CITY OF ALBUQUERQUE

October 4, 2022

RE: Presidential Cultivation
9910 Acoma Rd SE
Grading and Drainage Plan
Engineer's Stamp Date: 5/12/2022
Hydrology File: L20D076

Based upon the information provided in your resubmittal received 9/17/2022, the Grading & Drainage Plan is **not** approved for Grading Permit. The following comments need to be addressed for approval of the above referenced project:

Grading Plan

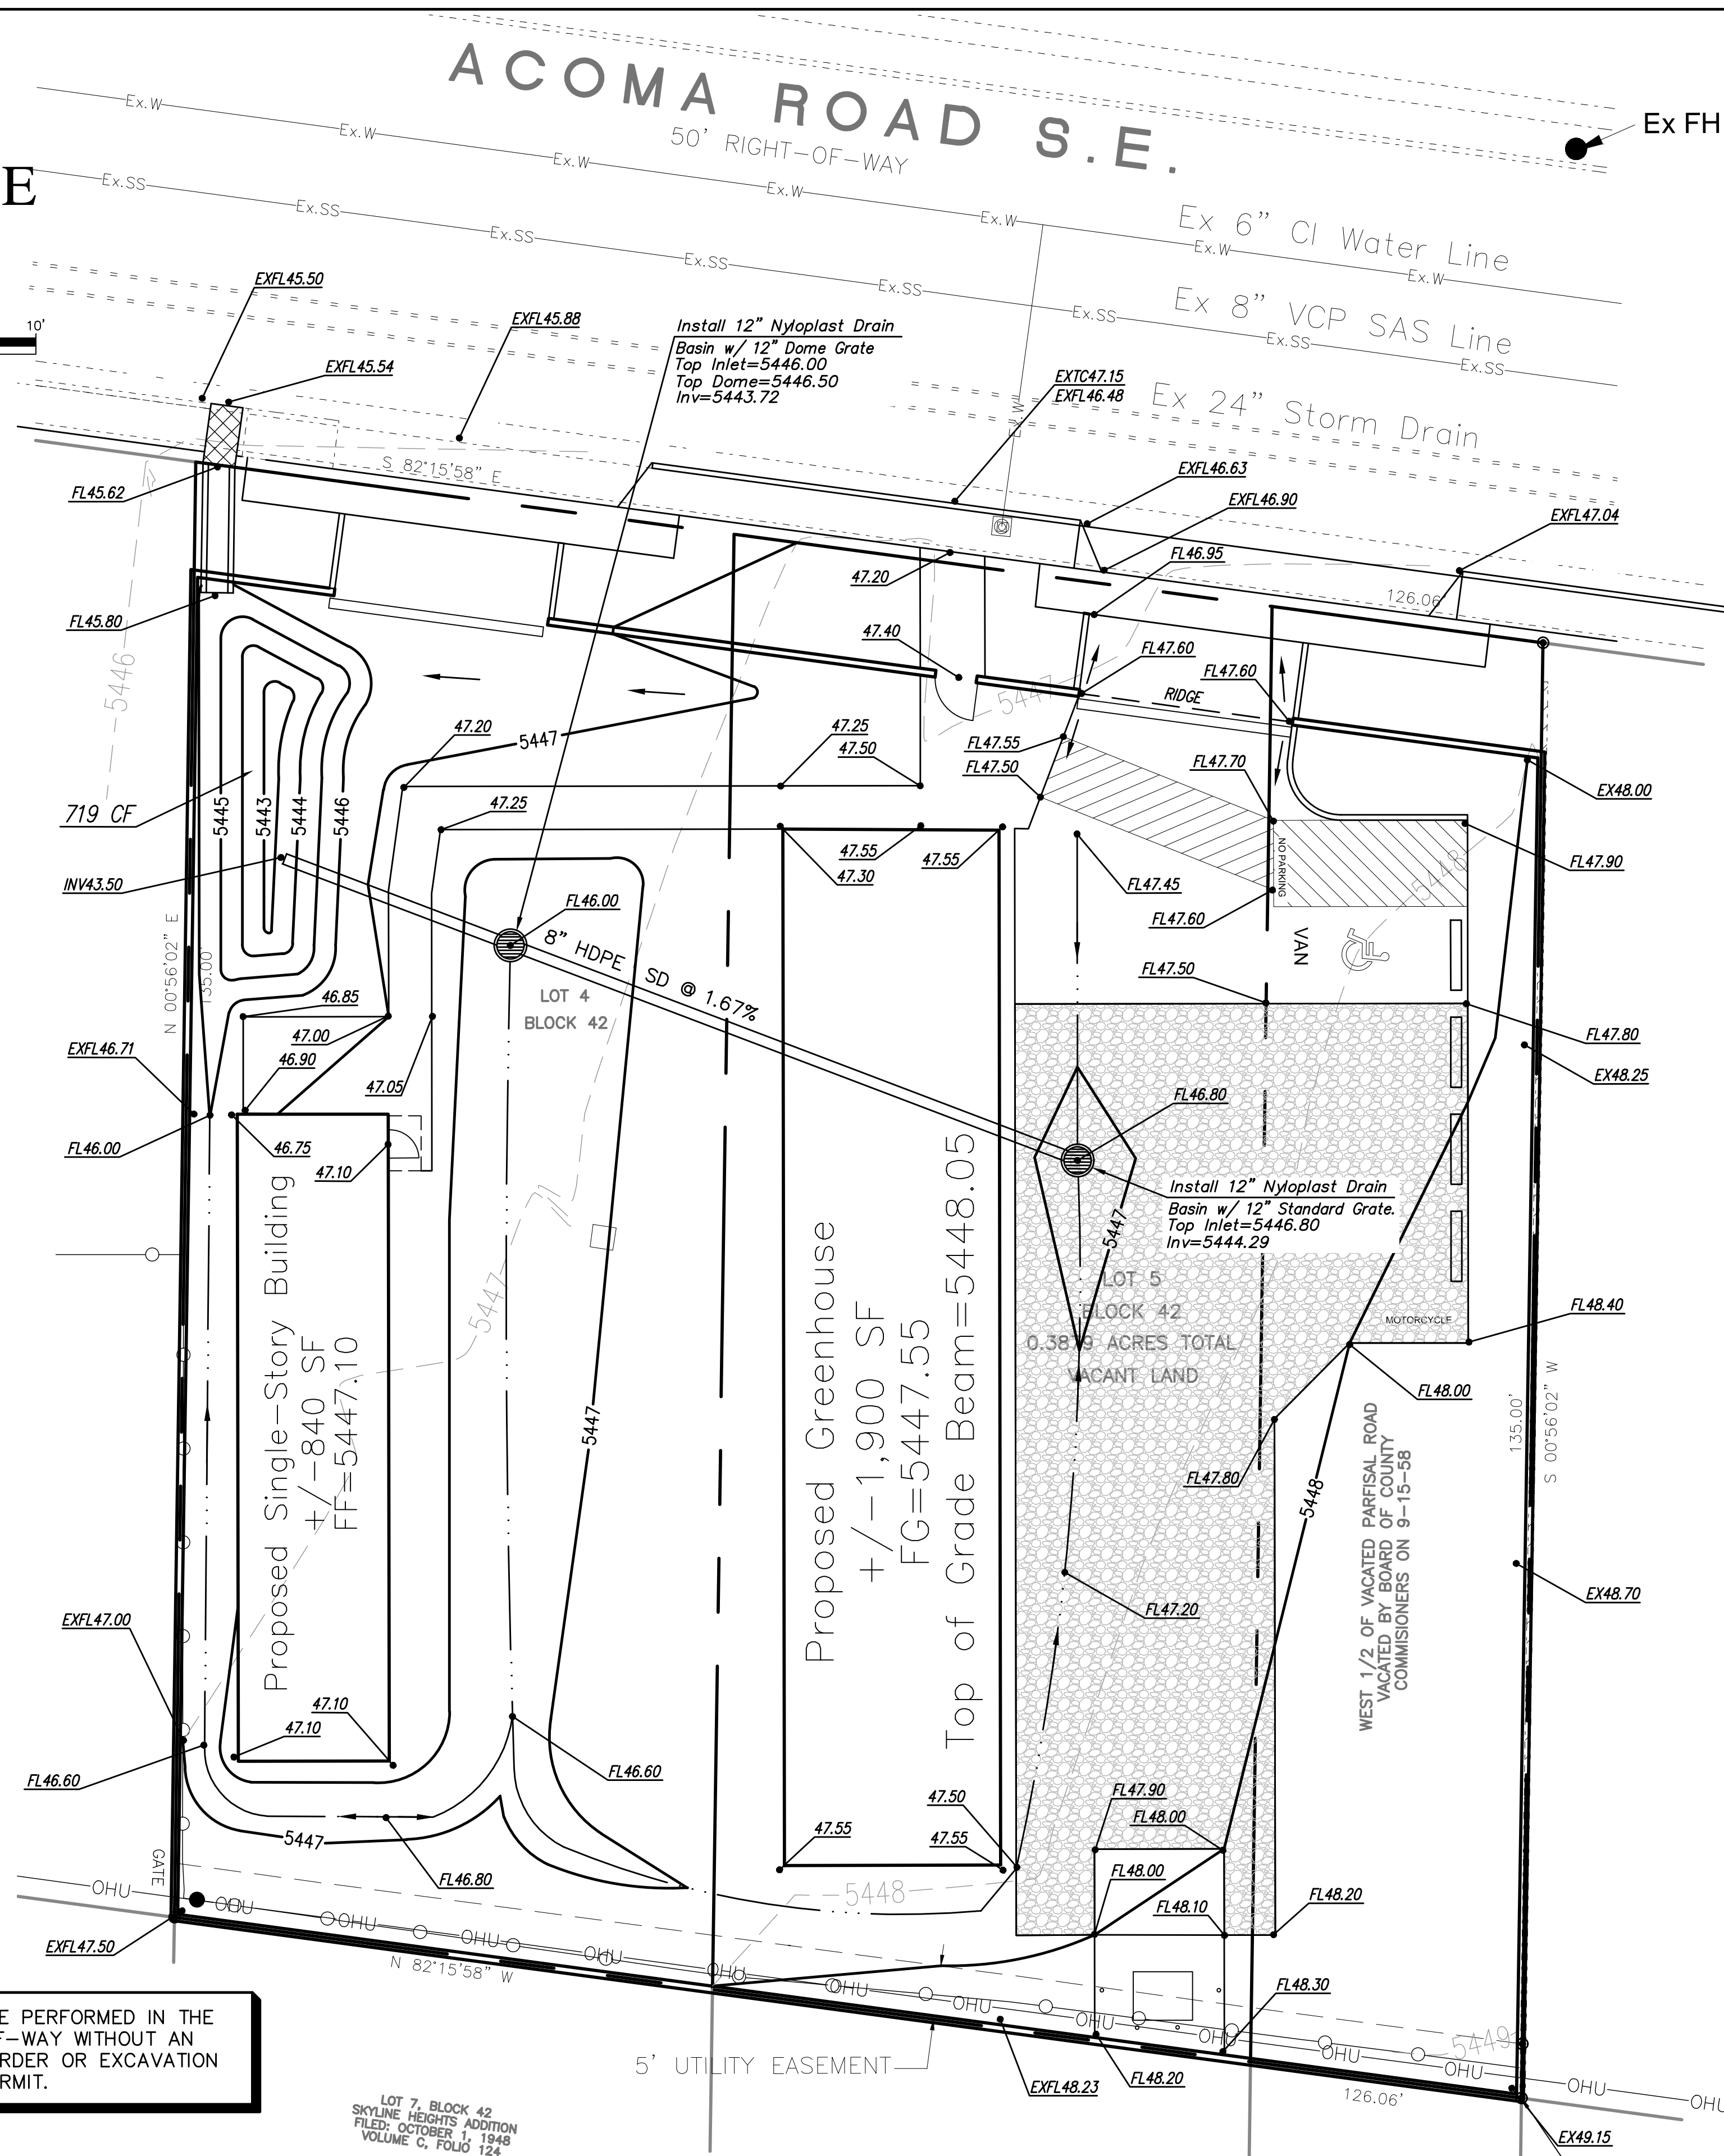
1. Please provide details of the culvert including the entrance to assure ADA is met.
2. Add city standard DWG number for the entrances.
3. Please address the following comments regarding the details shown below:
 - a. There is a discrepancy between the drawing and the title. The drawing shows a 3 foot clear width concrete flume whereas the title is 2 foot of concrete flume.
 - b. Flume width and wall opening must be the same as sidewalk culvert.
